City of Albuquerque Stormwater Construction Site Inspection Report

General Information					
ESC File No.	C09E011B		Project Name:		Bedrock at The Trails
NPDES Id. No.	NMR1005SI		Location:		9300 Woodmont Ave. NW
10/16/2024		Owner		Contractor	
Operator		Bedrock ABQ Investors, LLC (La Terra Development, LLC.)		LT Building Corp.	
Contact name & title		Julia Golden		William Leahy President	
e-mail		juliag@laterradev.com		williaml@ltbuildingcorp.com	
Contact Phone #		505-310-9545		310-552-0065	
COA Inspector		Chancellor English		Start/End Time: 130pm	
Construction Phase:		Cleared, blasting, and grading			
Type of Inspection:		Regular	Storm Event	Past Storm Event >0.25"	311/Complaint Follow Up
Weather at time of inspection?		cloudy		Temperature: ~ 75	
Estimated date of last storm 0.25" or greater		8/31/2024

BEDROCK DRAINAGE MANAGEMENT PLAN

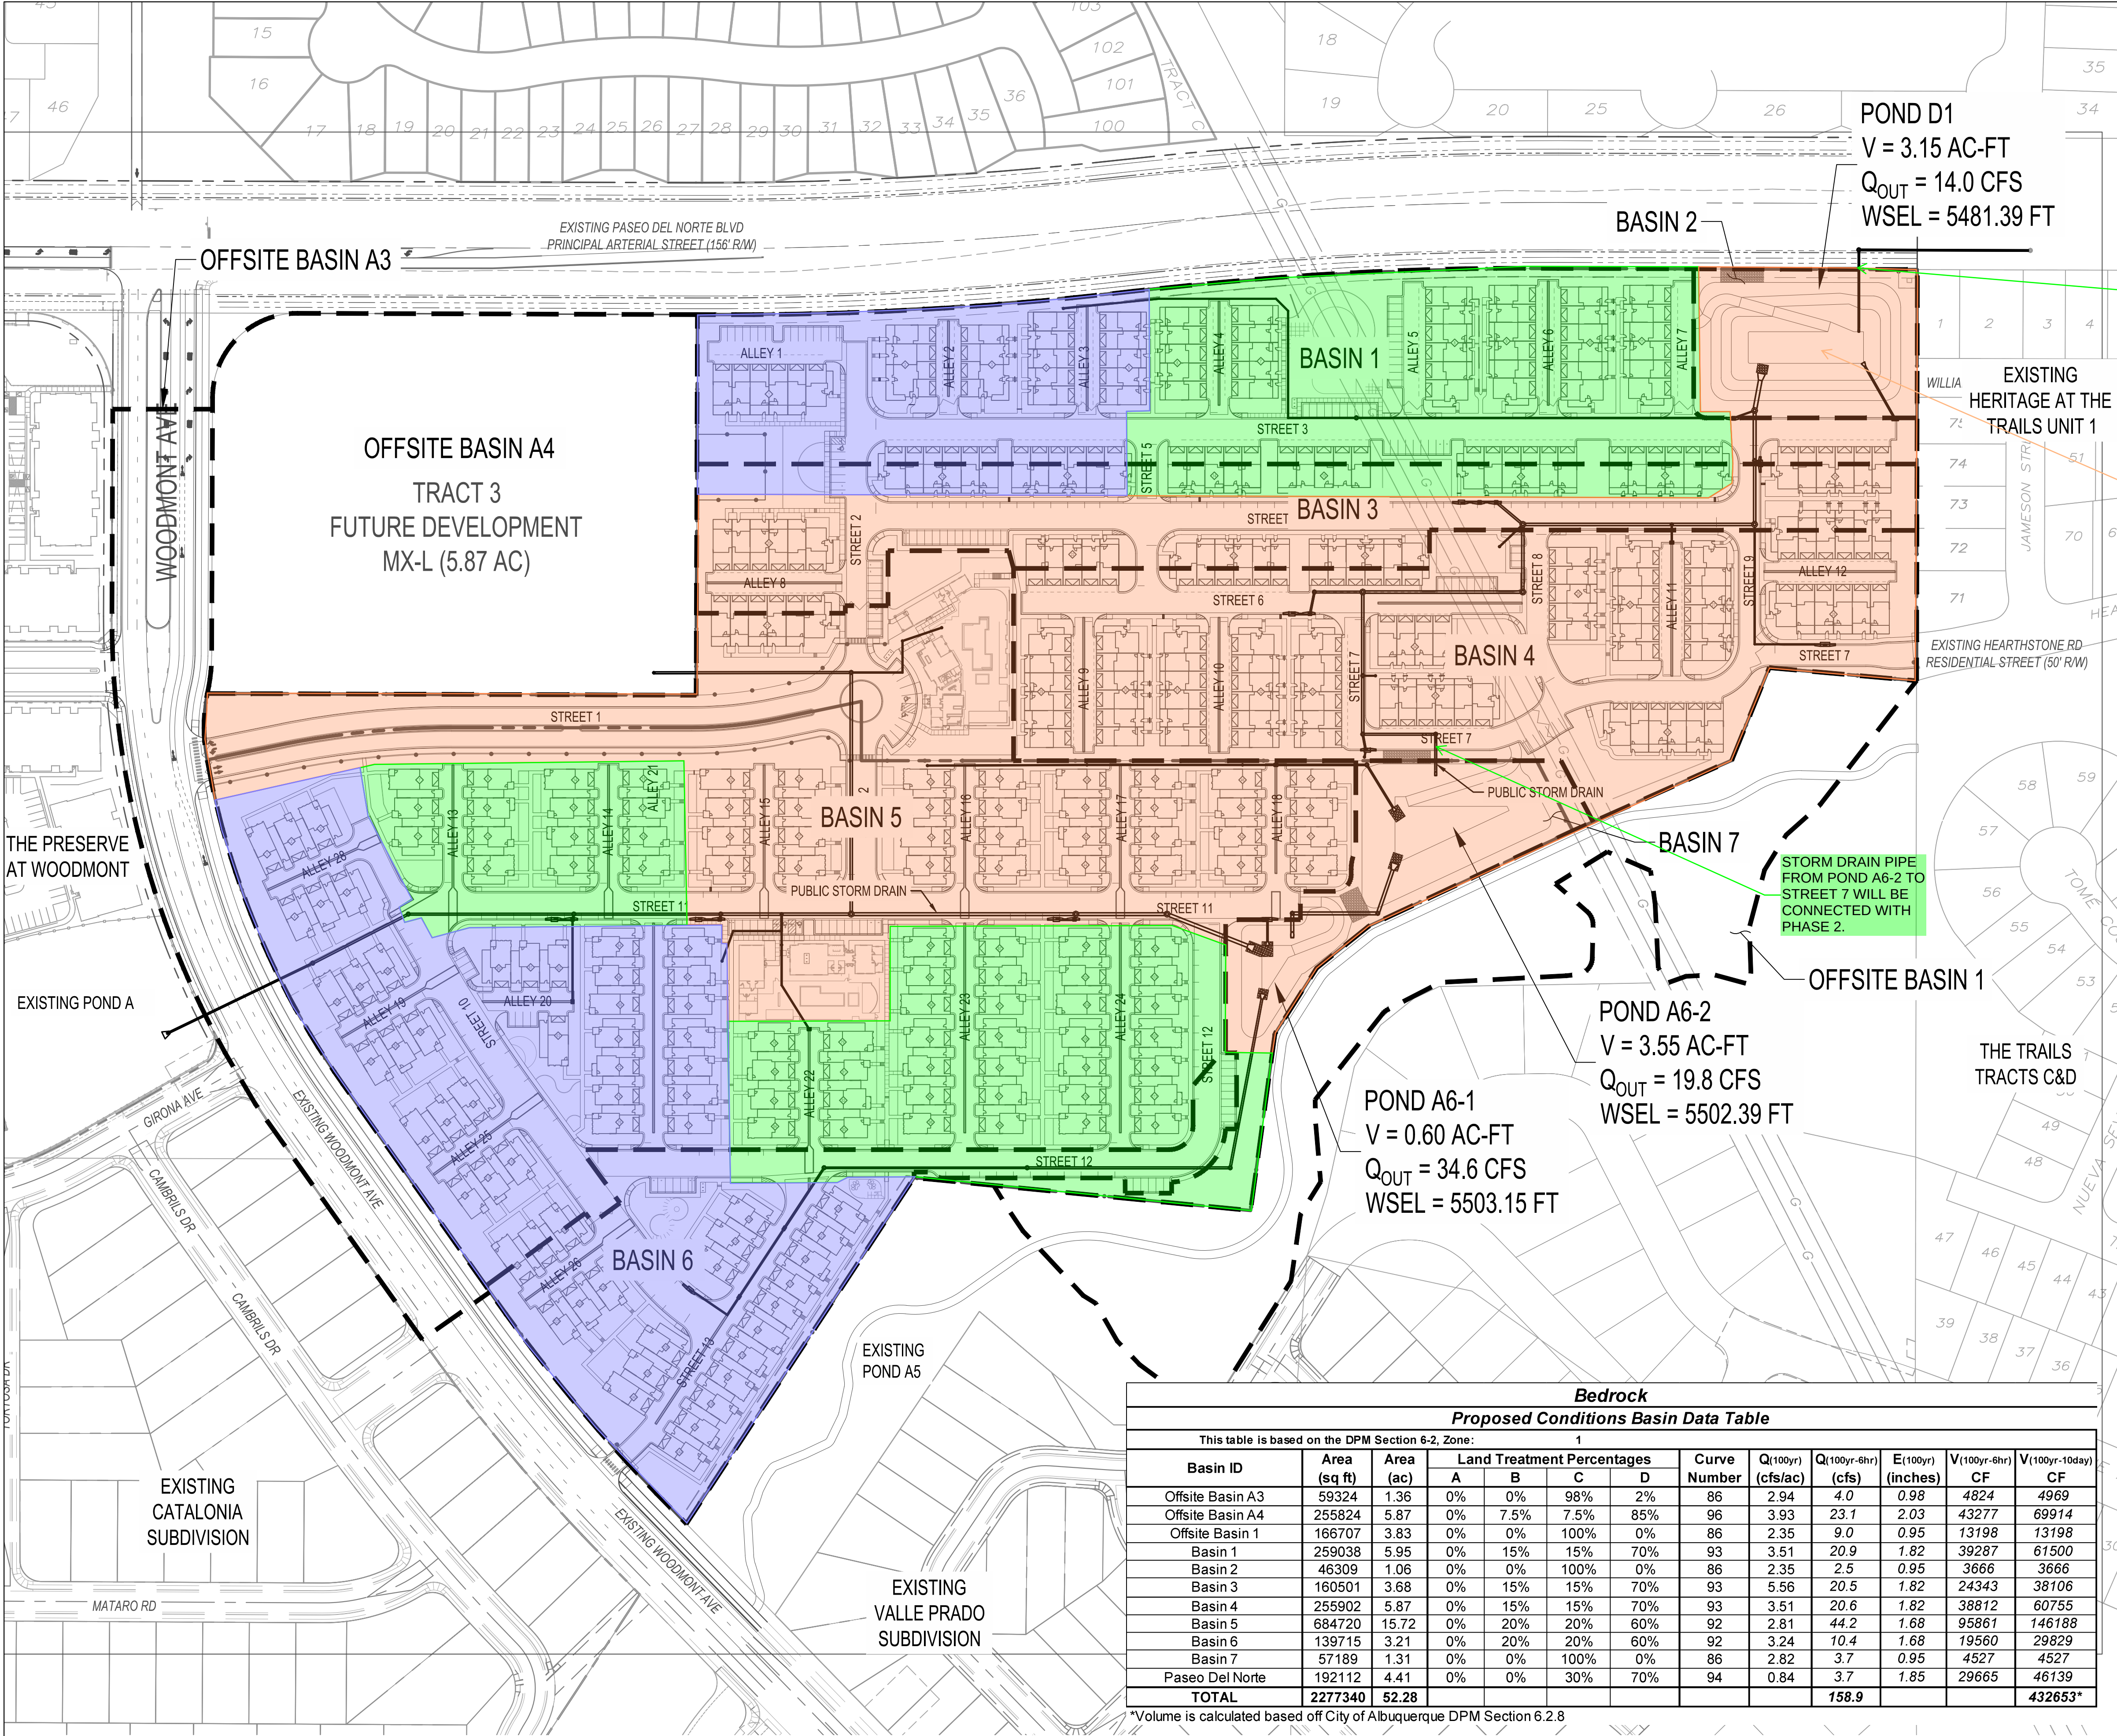
Item Number	Deficiency/ Corrective Action				
1	BMPs - Sediment has built up to nearly the top of some areas of silt fencing in violation of CGP Part 2.1.4. Required mitigation: Ensure all stormwater controls are maintained and remain in effective operating condition during permit coverage and are protected from activities that would reduce their effectiveness per CGP Part 2.1.4. Remove sediment before it has accumulated to one-half of the above-ground height of any perimeter controls per CGP Part 2.2.3.				
2					
3
